20 July 2021

Loreto Normanhurst Concept Plan and Stage 1 Works – SSDA 8996 Request for Information

Drawing Title  
**PROPOSED BUILDING**  
**ENVELOPE SITE PLAN**  
Sheet Status  
**NOT FOR CONSTRUCTION**

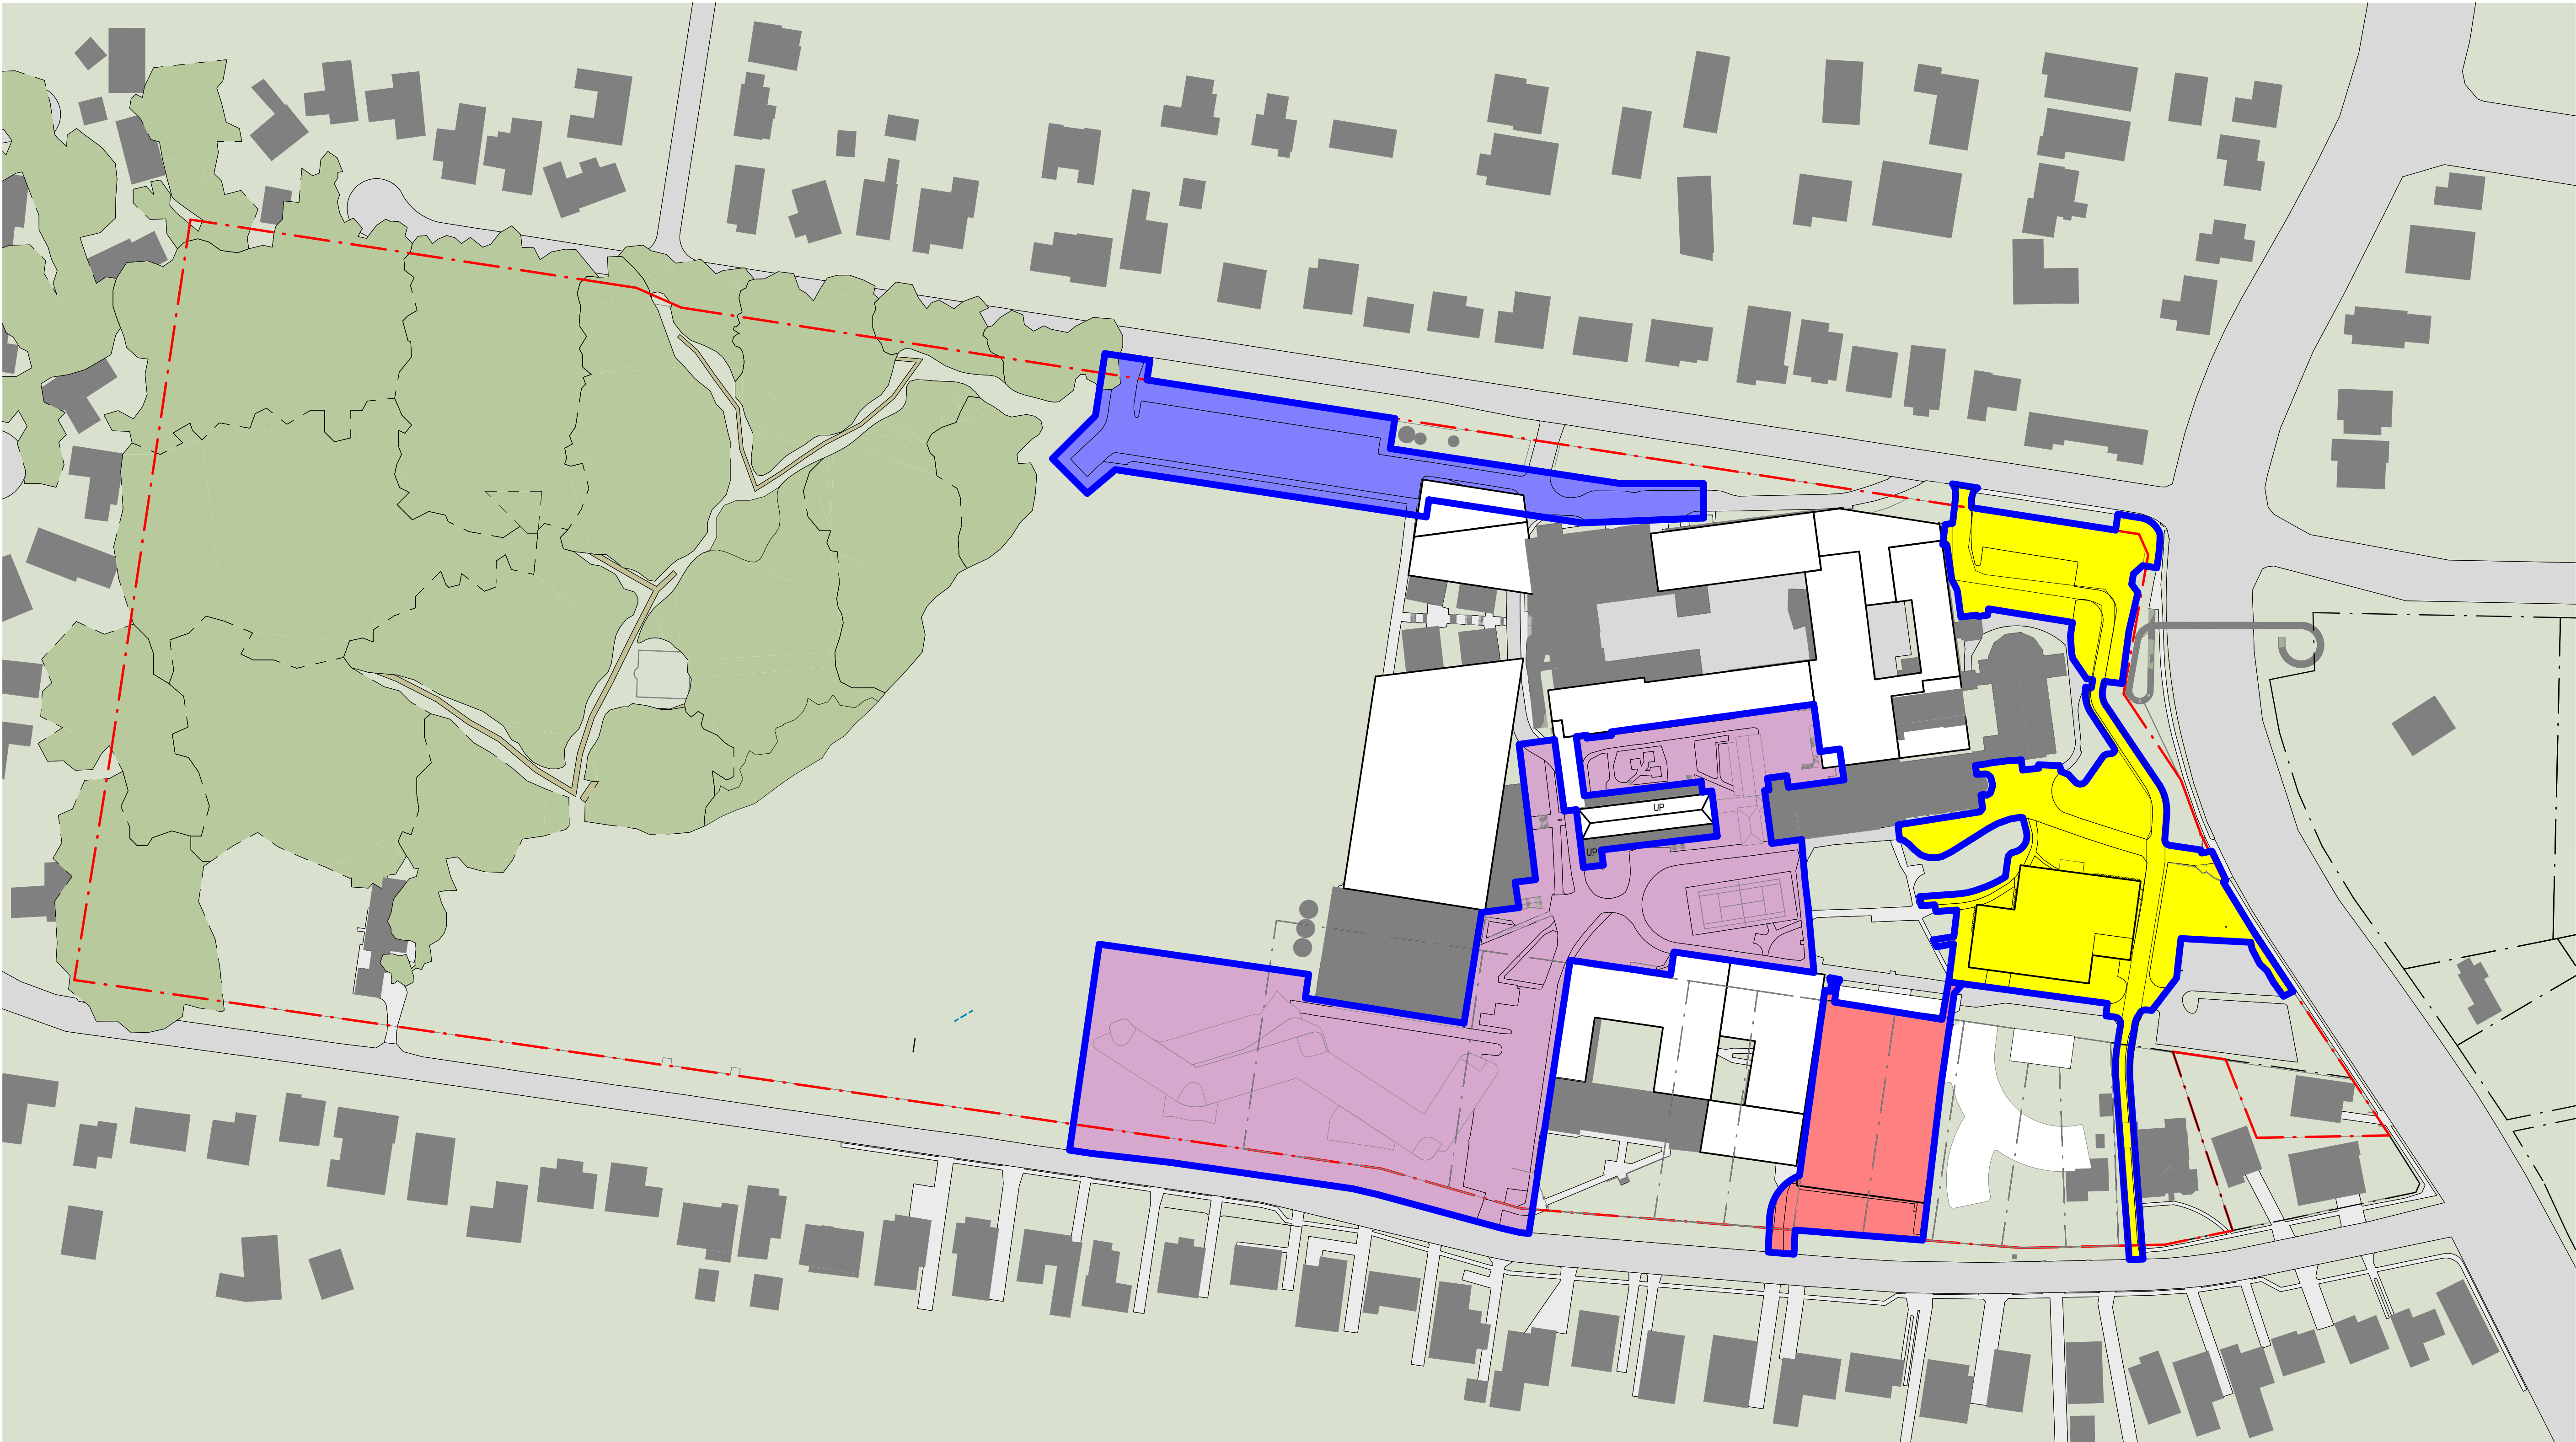
<p>(f) Concept Drawings The Concept drawings (A0027 to A0046) need to be updated to indicate the demolition of the 1960s connecting buildings between Mary Ward and Givendale buildings. The plans incorrectly show these buildings already removed.</p>	<p>See updated Concept Plan at Appendix D.</p>
<p>(g) Uniform Shop The SRtS states that the uniform shop demountable building will be temporarily relocated to the future Early Learning Centre (ELS) site until the ELC building is completed. The uniform shop would then be located to another building within the campus. While the indicative relocation of the uniform shop is shown on the aerial image in the SRtS, this needs to be shown in the architectural set of drawings. Accordingly, please include drawings in the architectural set to reflect the proposed temporary relocation of the uniform shop building. Please also include an estimated timeframe for completion of the ELC site / removal of the uniform shop building from the site.</p>	<p>The demountable uniform shop has been included in the Stage 1 overall plans at Appendix E. As the uniform shop is now shown on the plans, for the avoidance of doubt, the uniform shop demountable structure is sought for approval.</p> <p>The uniform shop will be removed prior to the construction of the ELC.</p> <p>The ELC is estimated to begin construction following the completion of Stage 1 works (September 2022) and within the approved commencement period of the Development Application. Construction is estimated to take 18-22 months.</p>
